## **Application by National Highways for A47 Wansford to Sutton Dualling**

### **The Examining Authority's further written questions and requests for information (ExQ2)**

Issued **5 April 2022**  
Deadline **20 April 2022**

Annex H - Relationship of Effect on Scheduled Monument, SSSI, veteran tree T20, and Flood Compensation

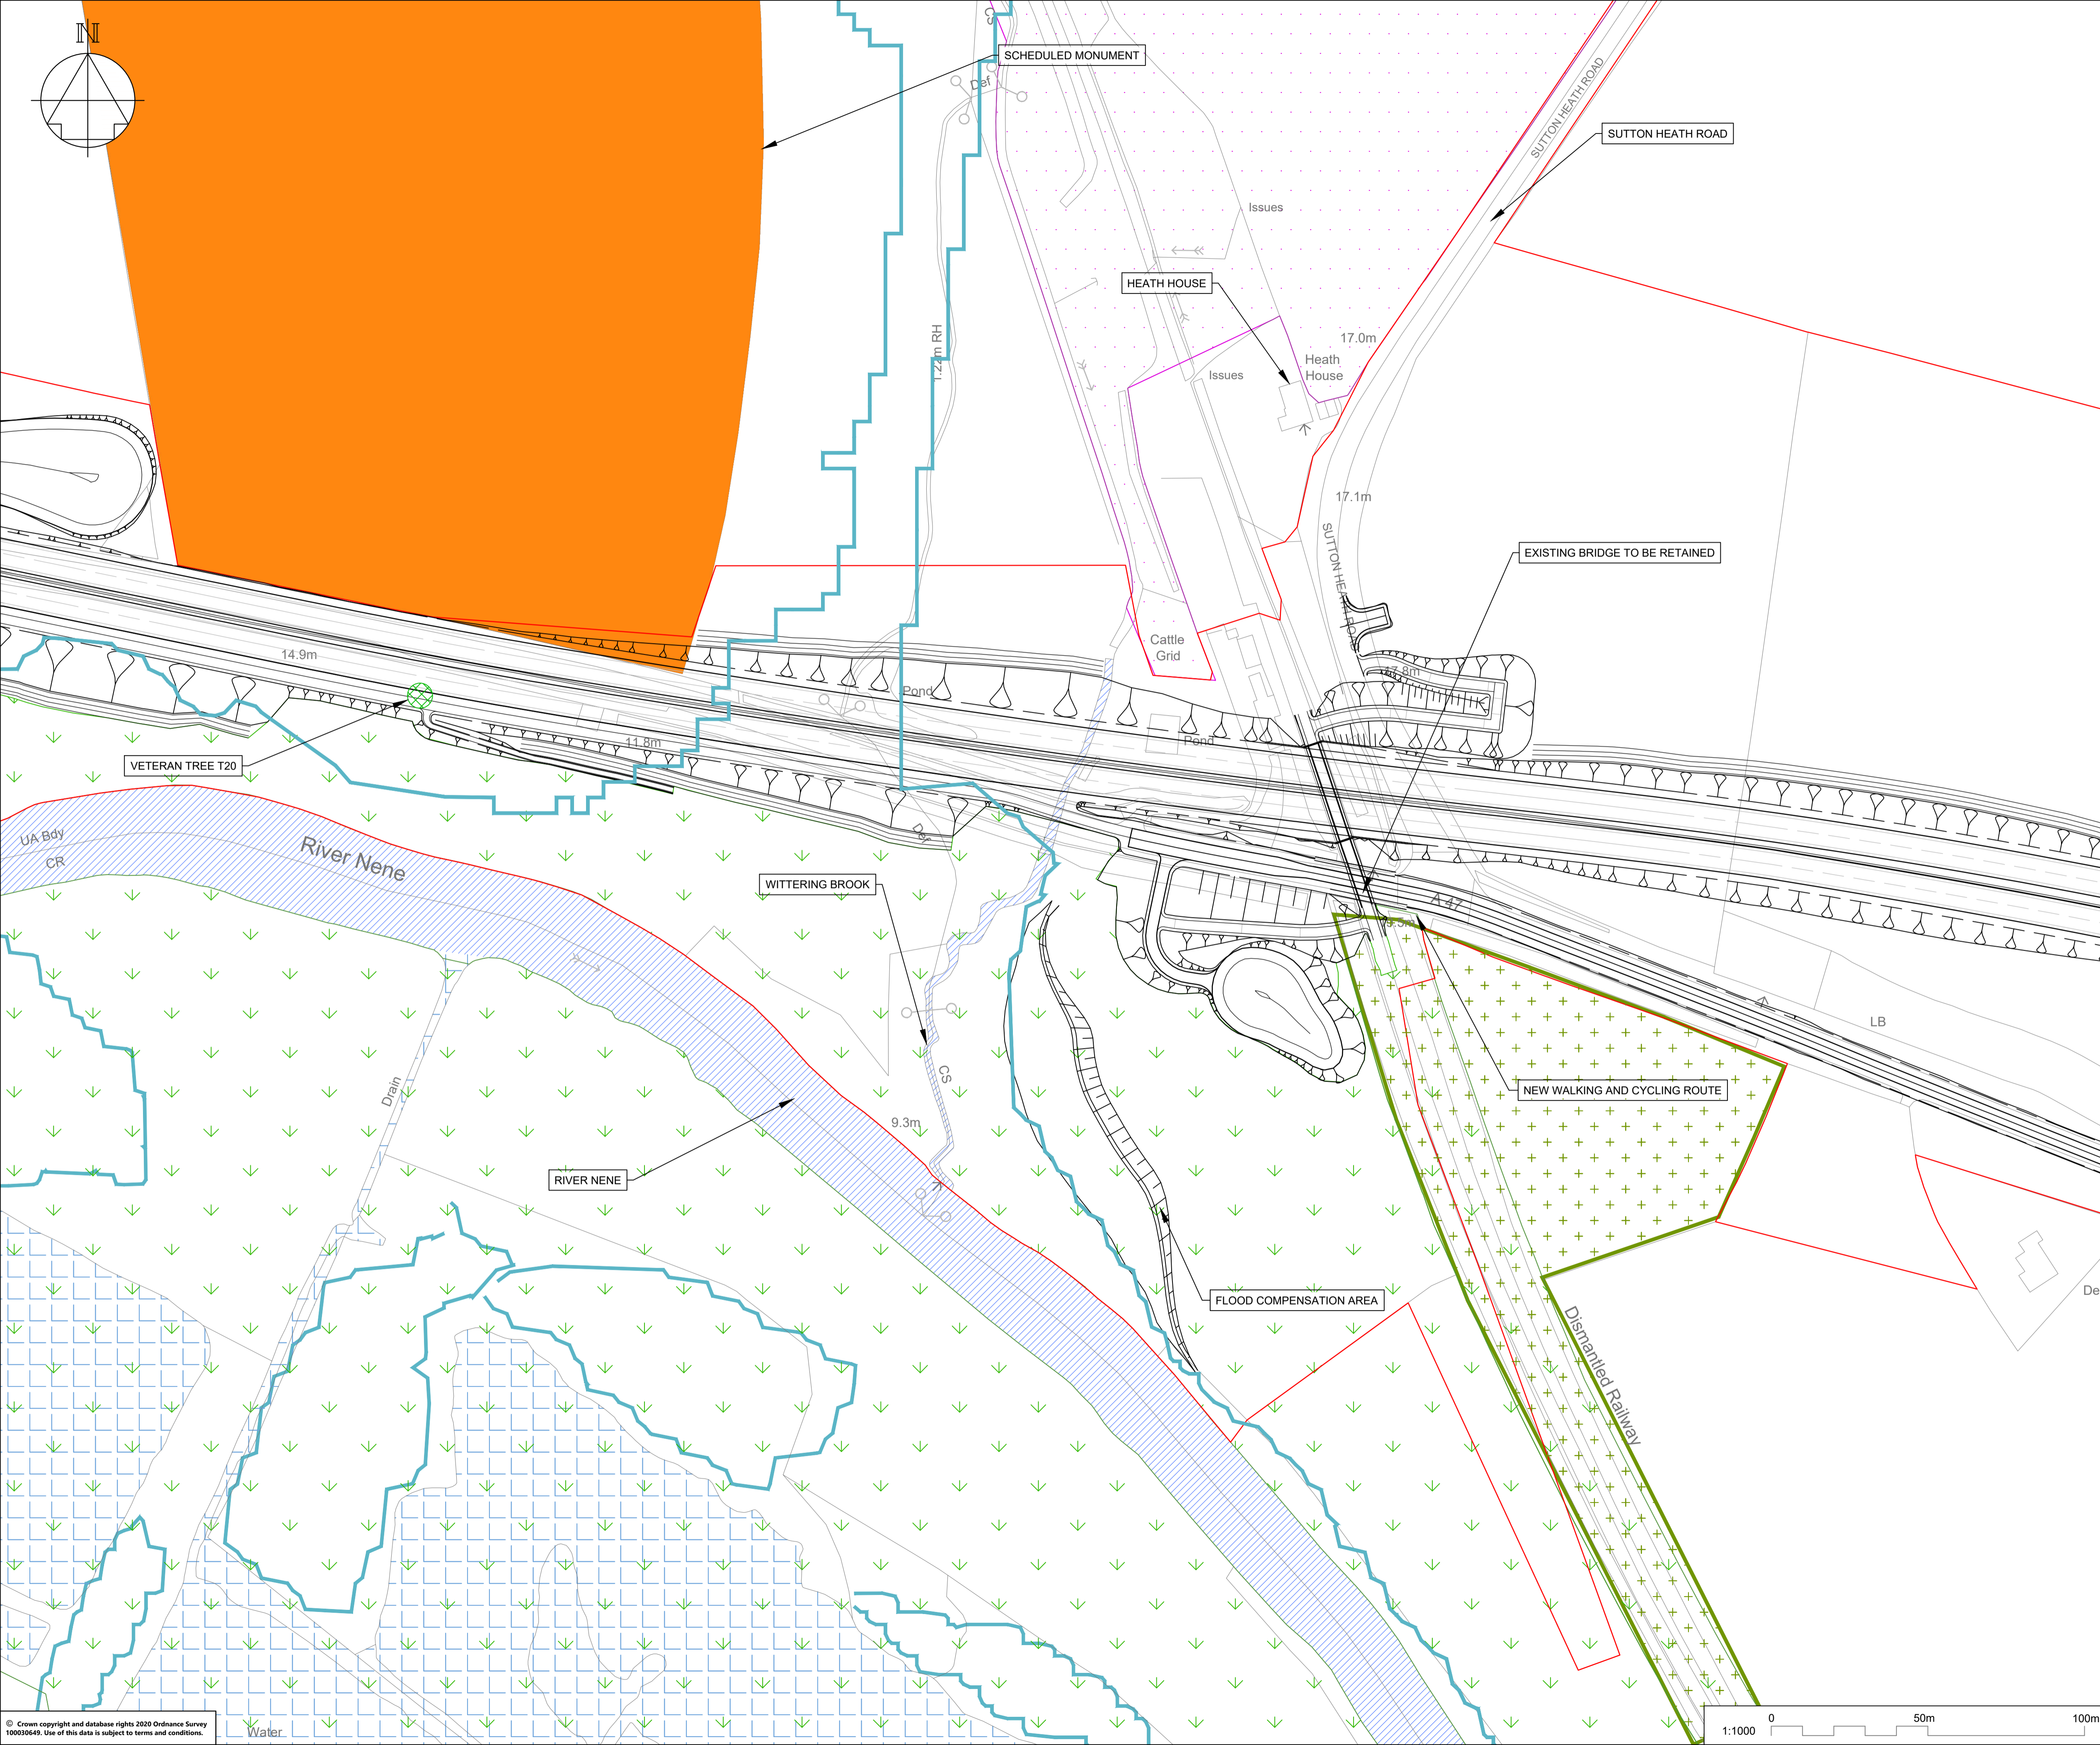
2.2.3.	The Applicant	<p><b>Veteran tree (T20)</b> In its response to ExQ1.2.11 the Applicant indicates that a revised ES Appendix 7.6 Arboricultural Impact Assessment would be submitted at D2. This was submitted as [REP2-022]. However, this document is noted in the Version History of the assessment (rather than the cover sheets) as being Version D which was last</p>

ExQ2	Question to:	Question:
		<p>amended in June 2021 and is only described as “Amended layout” rather than any changes of substance.</p> <p>At D4 the Applicant submitted a further version [REP4-007] but this is stated as only having amended the cover rather than the report.</p> <p>a) Could the Applicant please explain what the revisions between the versions originally submitted [APP-096] and that submitted at D4 [REP4-007] contain? To assist this could Version D please be supplied in a tracked change version from Version C (or if further amendments are submitted at D5 (20 April 2022) the tracking should be ‘back’ to Version C).</p> <p>b) The Applicant has indicated that the compensation is “part of the planting proposals”. Could the Applicant explicitly set out those parts of the planting proposals that would have been omitted had not there been a veteran (or locally notable) tree to compensate for. The ExA points out that if this cannot be explicitly stated then logically the planting would not be compensation for this loss.</p>

LOWER LODGE FARM EXISTING & PROPOSED JOURNEY LENGTHS

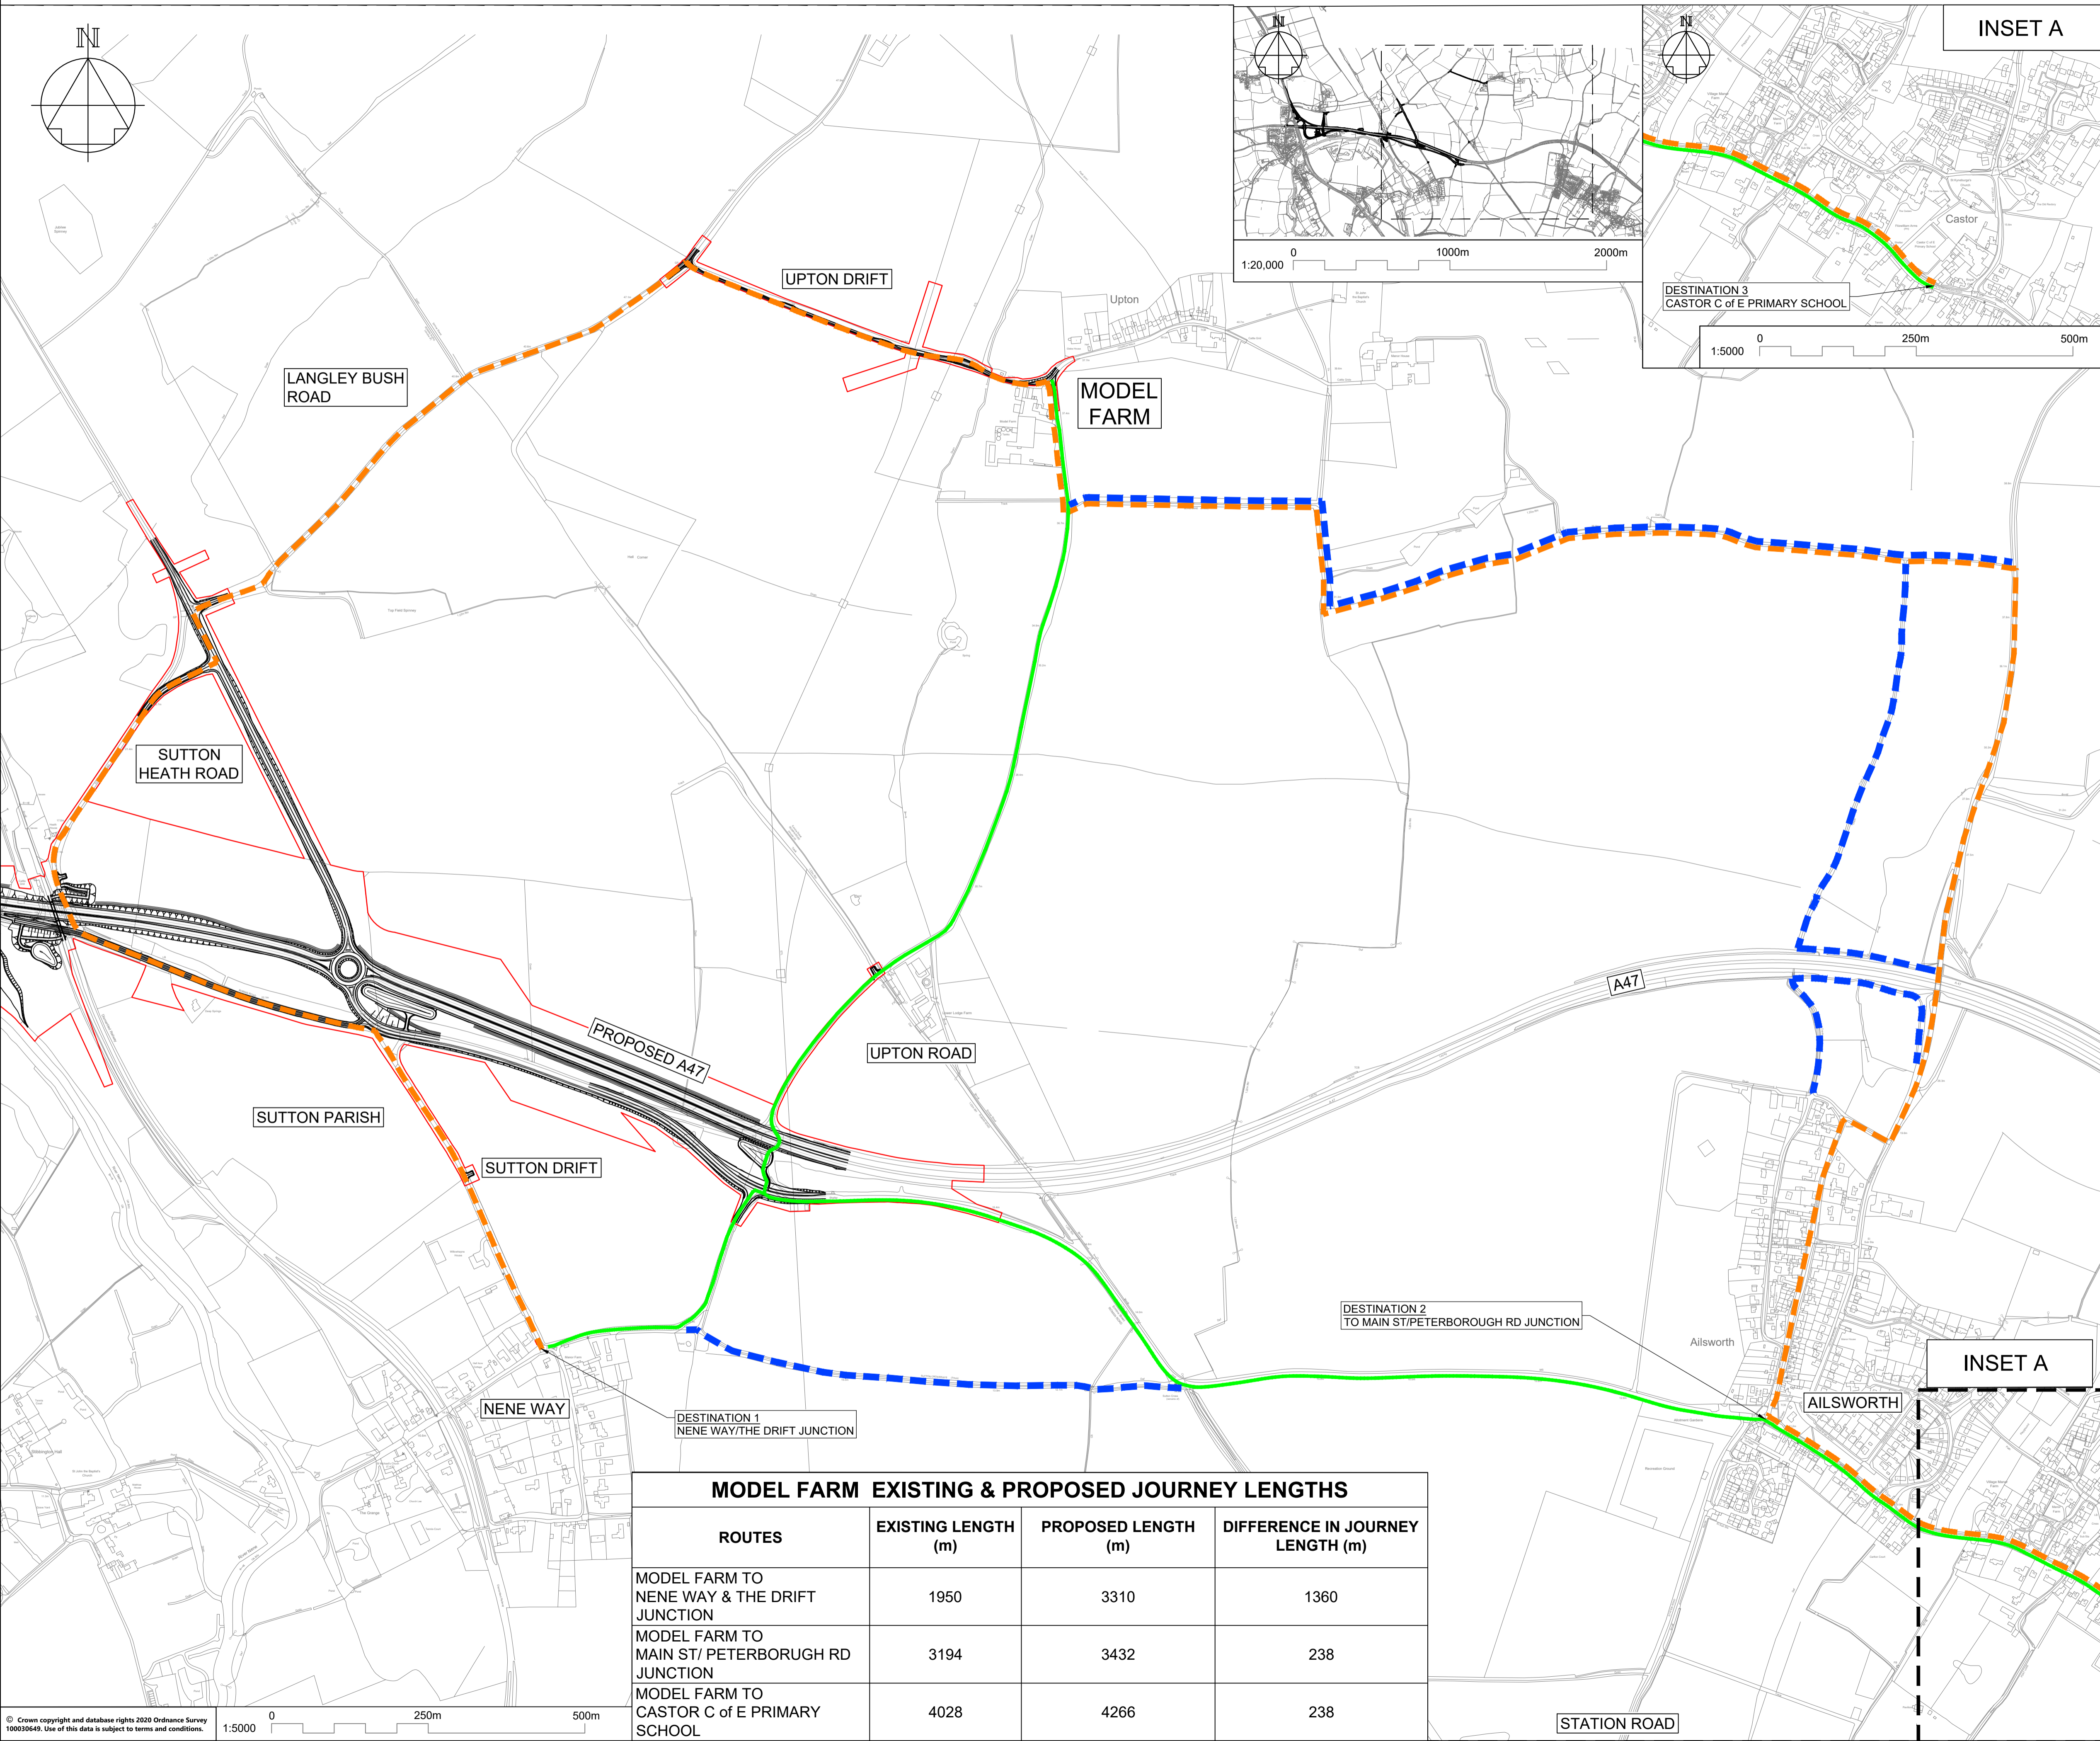
2.11.1.	The Applicant	<p><b>Stopping up of Upton Road south of Lower Lodge Farm</b> The Applicant indicates that alternative provision is to be made via the Wansford NMU underpass. Could the Applicant please set out the distances that a WCH would have to travel from Lower Lodge Farm to the existing junction of the A47 with Sutton Heath Road, in both the existing and proposed scenarios. The routes should also be shown on a plan to an Ordnance Survey base.</p>
